OUR REF: HS2-LBH-SC-027

Subject: [EXTERNAL] Planning Consultation for 2382/APP/2023/2906

BROADWATER LAKE MOORHALL ROAD HAREFIELD

Proposal: Redevelopment of the site to create the Hillingdon Watersports Facility and Activity Centre including demolition of existing Broadwater Lake Sailing Club (BSC) clubhouse at the north of the lake and erection of a building including changing facilities, meeting rooms, storage, Workshop and seasonal worker accommodation (sui generis), activity shelters; installation of pontoons and slipways; boat shed; equipment storage huts; boat parking and racking areas; camping area; outdoor activity areas; ecological enhancement throughout the site; new pedestrian routes through the peninsula; landscaping including new woodland, dense vegetation screens and boundary treatment; access road; localised dredging and land reclamation; relocation of existing sailing area and creation of floating reedbeds within the lake; coach drop off and turning area; vehicle parking; cycle parking; and associated works. (Re-consultation following submission of amended plans and documents)

DRAWING
BROADWATER LAKE
MASTERPLAN

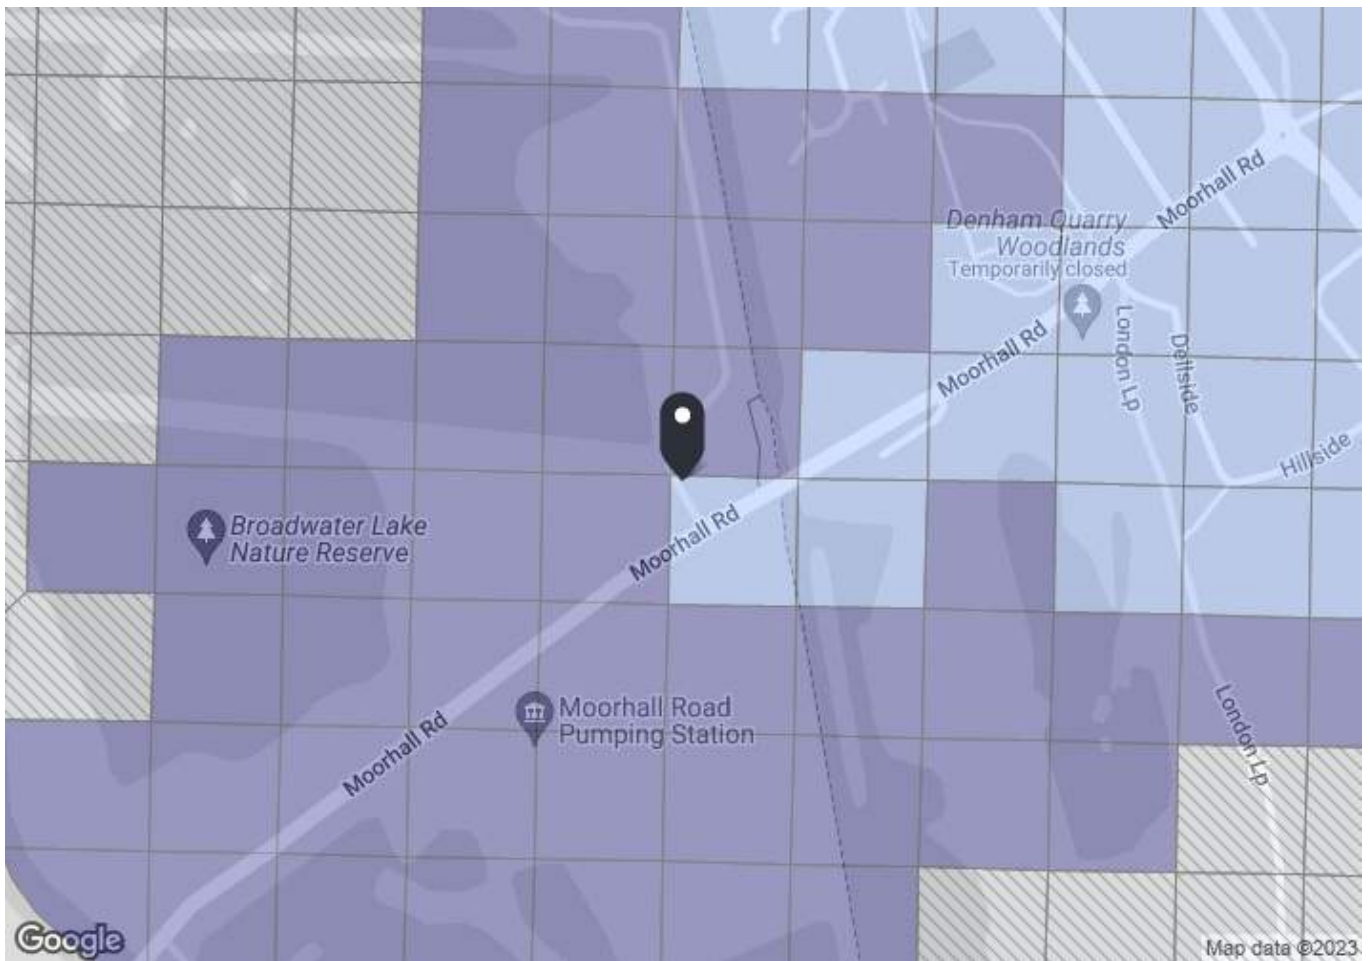
- From both the standalone plans and those embedded in other documents, it seems to show the approved HS2 floating gravel islands within Broadwater Lake (LBH reference: 73263/APP/2024/2181, approved on 22/10/2024) in slightly the wrong place, i.e. more northerly than HS2's own Schedule 17 plans.

- It is also noted the gravel islands are referenced in different ways depending on the plan/document being referred to e.g. *“Proposed HS2 tern rafts”, “HS2 mitigation: 5no. floating gravel tern rafts” “tern rafts to be funded by HS2”, “notional HS2 mitigation area”, “five floating gravel tern rafts to assist with HS2 mitigation”, and “five floating bird nesting rafts are proposed”*. It would be helpful if same terminology is used as HS2’s to be consistent across all of the applicant’s documents and it also made clear that the gravel islands are not proposed/notional, but approved by the LPA as of October 2024, so the revised planning application (dated November 2025) should reflect this.
